# 61 The Reddings, London, NW7 4JN

Pre-application report

Reference 20/0516/QCJ

Reference:	<b>20/0516/QCJ</b>
Location:	61 The Reddings, London, NW7 4JN
Proposal:	Proposed loft conversion to include rear and side dormers, raised crown roof, front and side velux roof windows and internal alterations.

Rev.	Scale:1:100 @A3 Date: 30/09/2020 Drawn: AU	Job: 61 The Reddings, London, NW7 4JN	Drawing No. 05/1070/PLAN/123.
------	--	---	----------------------------------

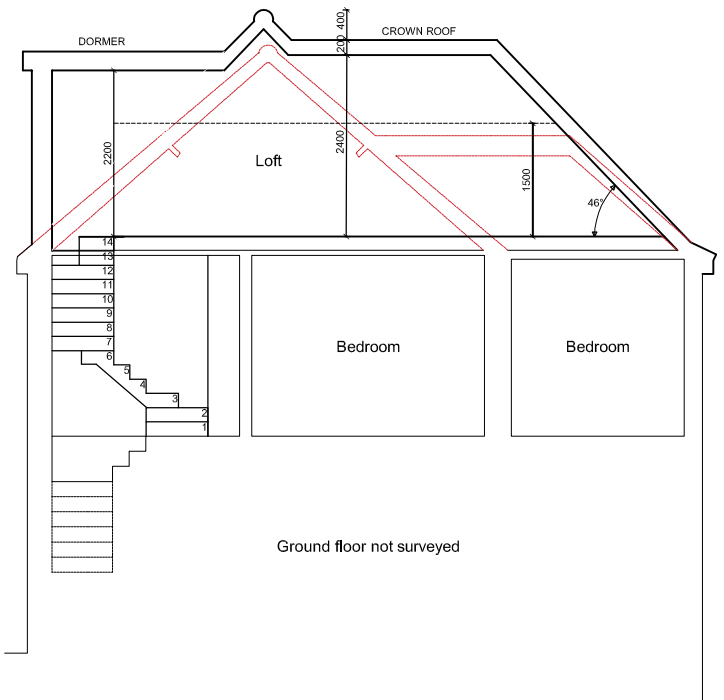
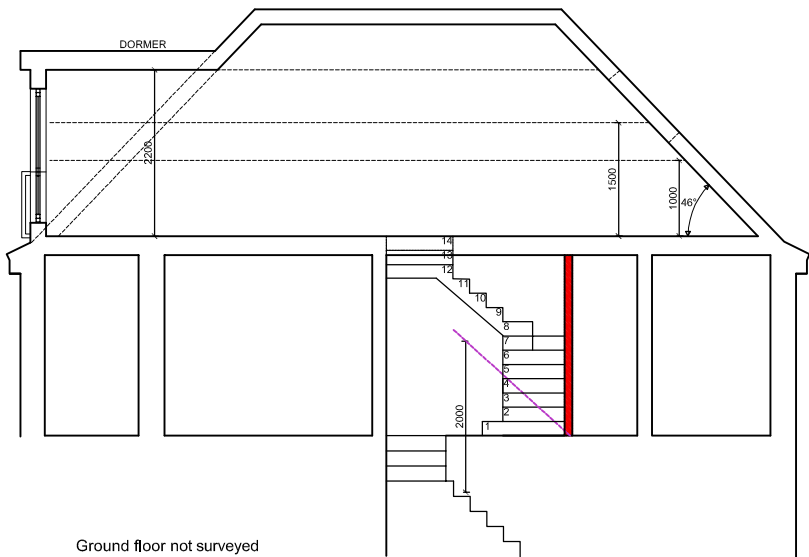
- 6.10 The proposal benefits from a crown roof as a result of the existing side and rear extension, however it is significantly set down from the main ridge. The proposal will see the pitch of the roof pulled forward marginally and increased by 0.4m. The crown will be increased in height to align with the highest part of the original roof. It will replace the staggered roof with a new hipped roof that would have a flush ridge line across the side and the rear extension. It is noted that the proposed increase in the height of the crown will not appear any larger than what exists. Furthermore, the new roof will appear symmetrical in shape and will sit comfortably within the street scene. The set back from the front elevation will be retained. Therefore, this element of the proposal will be acceptable, in terms of character and amenities.

- 6.12 Whilst the dormers would not occupy more than half the width of the roof slope, it would occupy more than half the height of the roof slope and will not appear to be a subordinate addition to the roof slopes. As stated above the property has already been redeveloped and the dormers are proposed on the extended roof. The addition on the 2no. dormers will add additional massing at the roof slope. Whilst there is no in principle objections to the dormers, the dormers will need to be reduced in scale. The height of the dormers will need to be reduce to half the height of the original roof. At present they appear to dominate the roof slope. This advice was also provided in the previous pre-application response and has not been addressed; therefore the Local Planning Authority would continue to object to the dormers as proposed.

- 6.13 The applicant is advised that any development involving the roof should carefully respect the proportions and appearance of the existing dwelling. The alterations should relate sympathetically to the main building and the buildings in the immediate vicinity. The proposed roof extension will increase the bulk and massing at roof level. Combined with the large dormers, it would appear unduly bulky and visually obtrusive, mainly due to the size of the dormers. Therefore, the extension is not considered to be a subordinate addition to the property.

- 6.14 The increase will be within the footprint of the property and therefore it is not considered to harmfully impact the amenities of the neighbouring properties, in terms of loss of light or loss of privacy. Notwithstanding this, the additional bulk and massing will be visible from neighbouring gardens, creating a visually obtrusive element to neighbouring occupiers.

- 7.1 As the application stands it would not receive a favourable recommendation and therefore amendments will be required for the proposal to be compliant with the relevant guidance and Local Plan Policies. Officers would recommend addressing the above points raised in the assessment prior to any formal submission.
